Rezoning Transportation Analysis

Petition Number: 2021-104

Revision Log:

Date	Description
08-20-2021	First Review (KP)
09-17-2021	Second Review (WB)
10-27-2021	Third Review (KP)

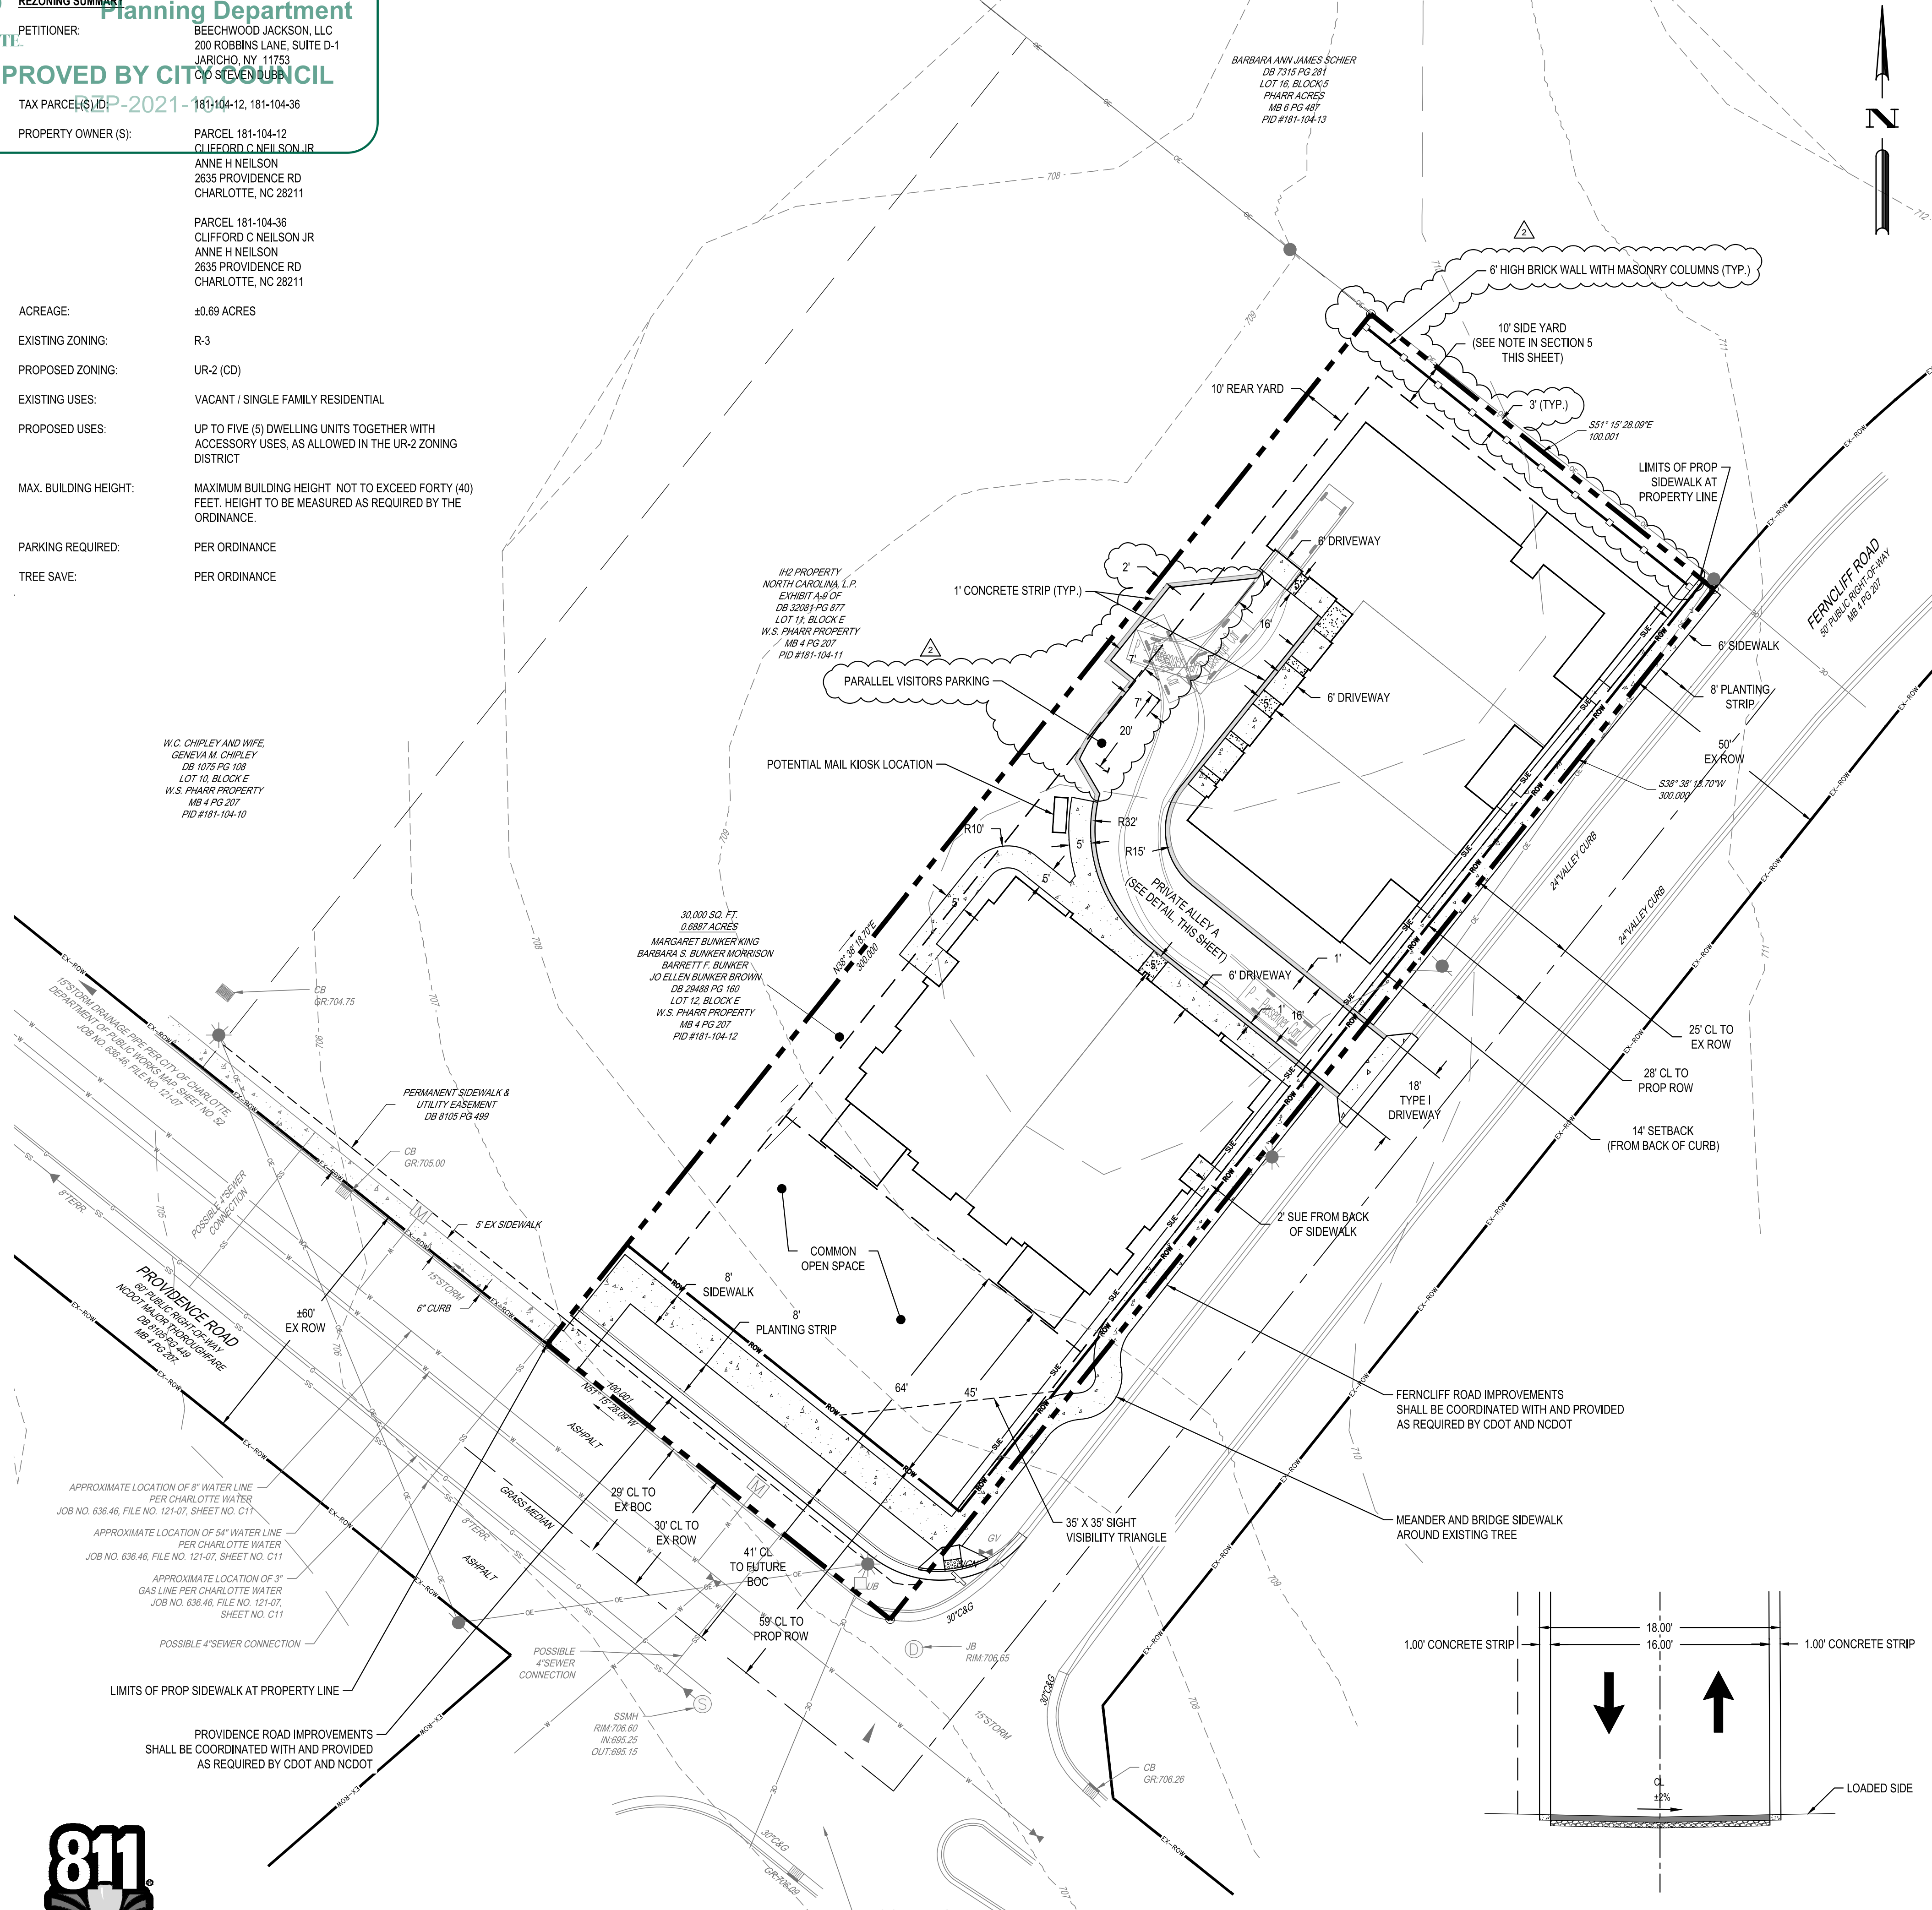
1. ~~Curb line: The proposed zoning district has a setback measured from back of the existing or proposed future curblines.~~
 - a. ~~Ferncliff Road: Location of curb and gutter may remain in it's existing location.~~
 - b. ~~Providence Road: The location of the future back of curb will be 41 feet from the existing centerline.~~

~~Label and dimension the existing and future back of curb from the centerline for each road on the site plan.~~

3. **Right-of-way:**
 - a. ~~Ferncliff Road: Revise site plan and conditional note(s) to commit to dedicate 28 feet of right-of-way from the road centerline~~
 - b. ~~Providence Road: Revise site plan and conditional note(s) to commit to dedicate 59 feet of right-of-way from the road centerline.~~

~~The site plan shall label and dimension the right-of-way from the existing centerline of each road.~~

4. ~~Revise the site plan by placing the 8-foot sidewalk, along the site's frontage of Providence Road, relative to the future curb line located 41 feet from the existing centerline of Providence Road.~~

6. ~~Revise the site plan and conditional notes by committing to construct an ADA-compliant curb ramp, to cross Ferncliff Road, at the corner of Ferncliff Road and Providence Road.~~
